4 February 2015

Planning Services
Department of Planning and Environment
GPO Box 39
SYDNEY NSW 2001

Re: SSD 14_6422 Teven Quarry Environmental Impact Statement (EIS)
Lots 1, 2 and 3 DP 732288, No.'s 129 – 181 Stokers Lane, Teven

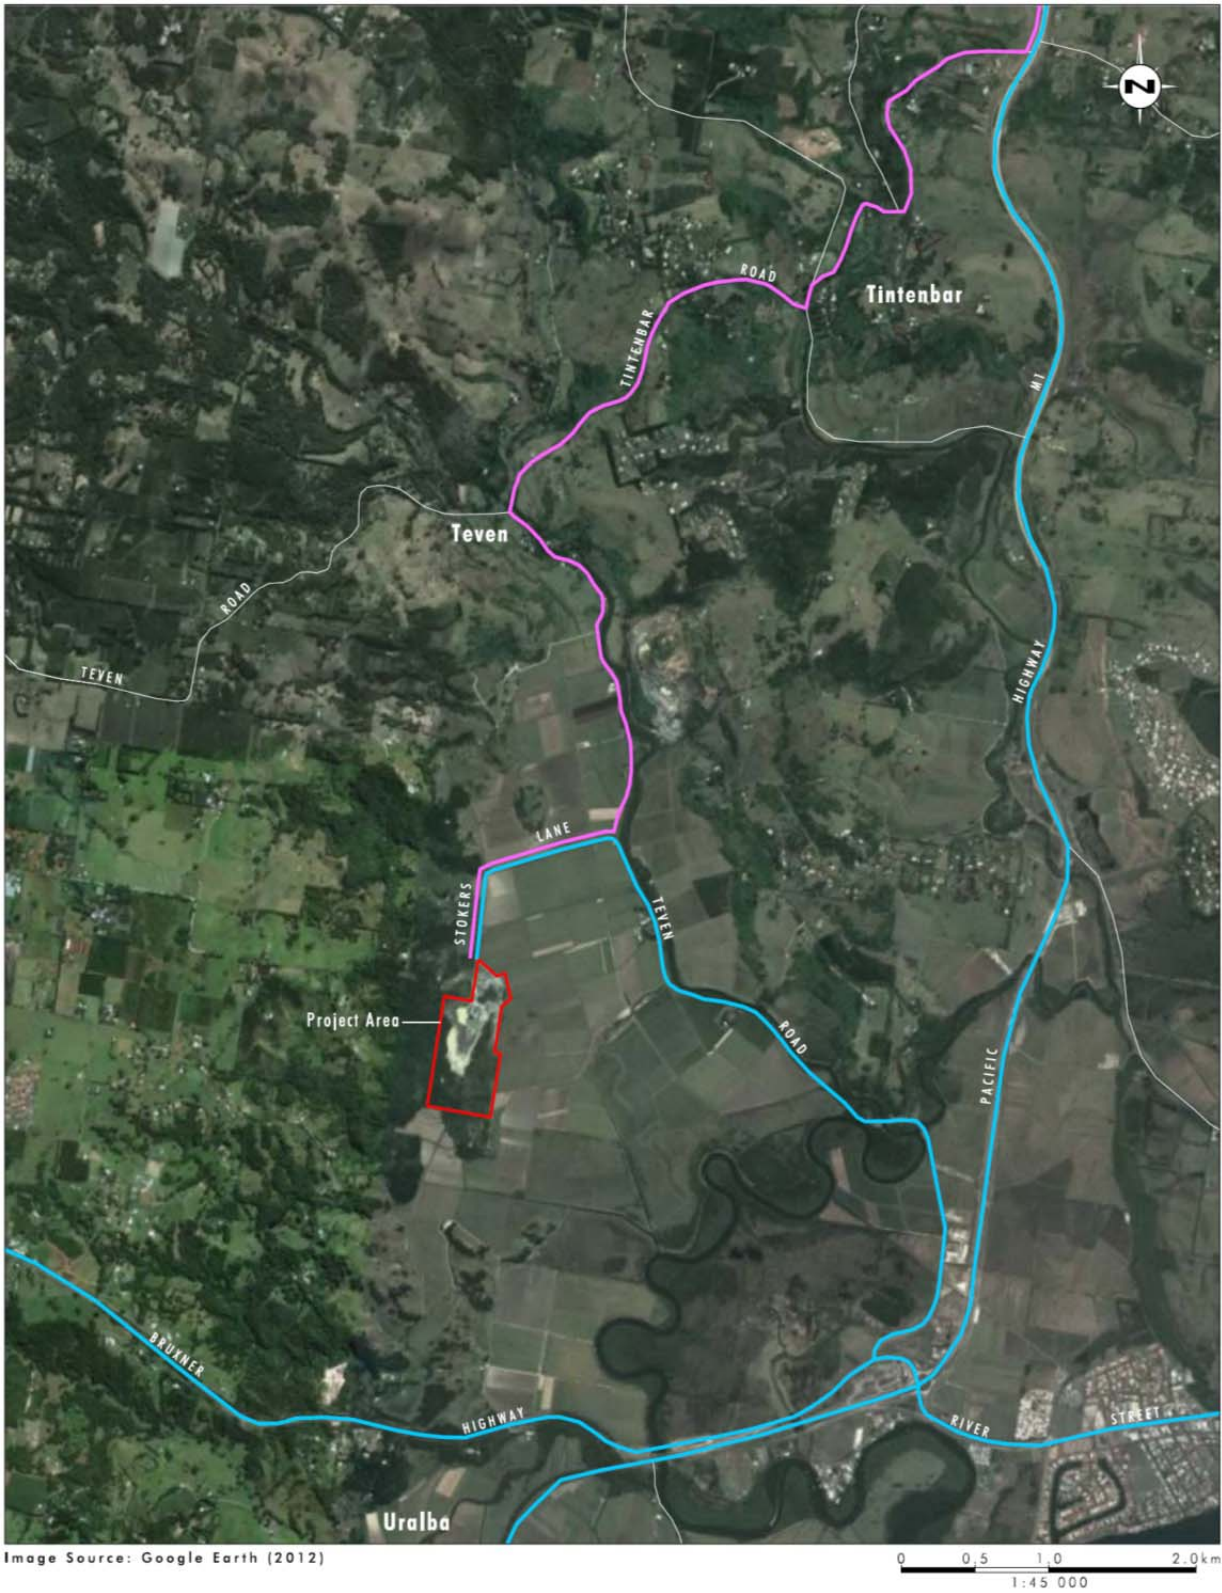
Of some concern is that Figure 3 shows Teven Road west of Tintenbar Road being a local transport route, but the submitted traffic volumes do not identify traffic (from the development) on this route. This matter is raised as the section of Teven Road, west of Tintenbar Road is steep and windy, has a poor accident record (including a recent head on fatality) and nearby residents report significant usage by Holcim delivery trucks, however impacts on this road are not addressed by either "Appendix 7 - Traffic Impact Assessment for Teven Quarry" and were not included in the scope "Appendix 8 - Road Safety Audit" Tintenbar Road east of Teven Road.

Further clarification should be requested for the market projections and delivery route assumptions that support the figures and route allocation apportionment provided by the proponent in EIS Appendix 7 including Tables 7.17, 7.18 and 7.19, an assessment of the current and projected traffic volumes on Teven Road west of Tintenbar Road and a revision of the scope of "Appendix 8 - Road Safety Audit" to include the section of Teven Road west of Tintenbar Road.

However, as advised previously, the scope of "Appendix 8 - Road Safety Audit" should be expanded to include the section of Teven Road west of Tintenbar Road and further road safety recommendations/conditions/commitments could arise from this expansion of audit scope.

- (a) Validate the market projections and delivery route assumptions that support the figures and route allocation apportionment (95% of deliveries will be on Route 1 and 5% will be on Route 2) provided in EIS Appendix 7 including Tables 7.17, 7.18 and 7.19, and
- (b) Provide an assessment of the current and projected traffic volumes on Teven Road, west of Tintenbar Road; and
- (c) Provide a revision of "Appendix 8 - Road Safety Audit" with additional scope to include the section of Teven Road west of Tintenbar Road.
